**Consultation Response from KC,
Lead Local Flood Authority**

**2023/93447 Truckline Services Ltd, Gordons Place, Manchester Road, Linthwaite, Huddersfield,
HD7 5RF**

Prior notification for change of use from office to two dwellings

Date Responded: 18th December 2023

01 FRONT ELEVATION

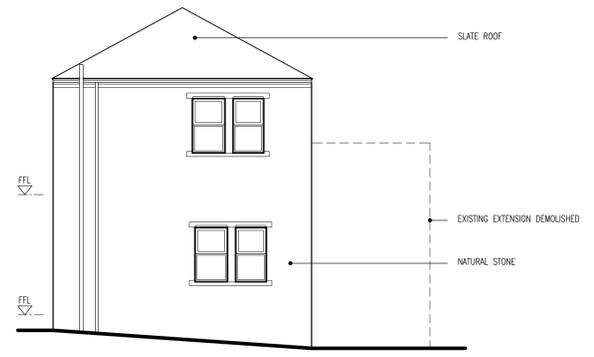
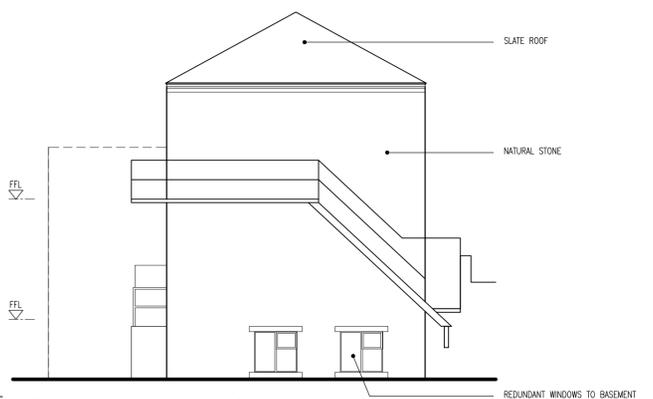
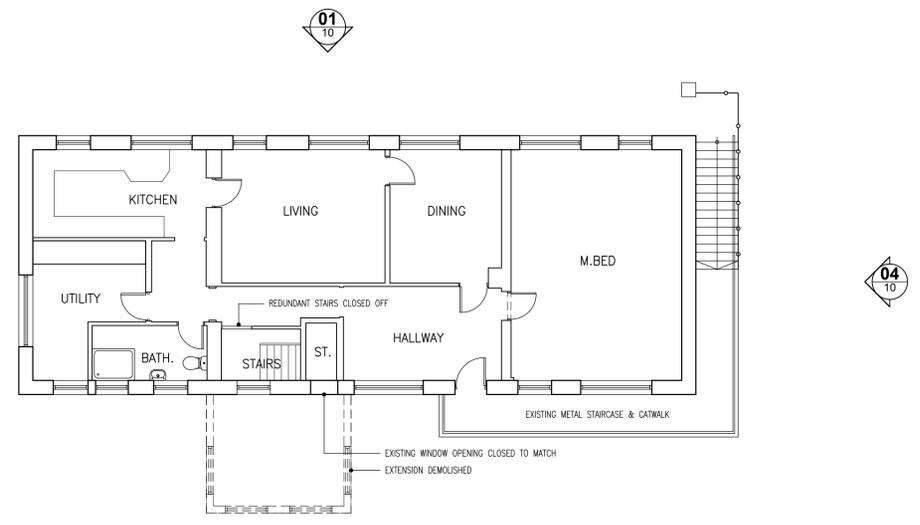
We have observed windows on the plan suggesting there is a lower ground floor that is not marked up on any floor plans. Providing the planning officer is satisfied that this cannot be use for habitable space, we have no objection to this application.
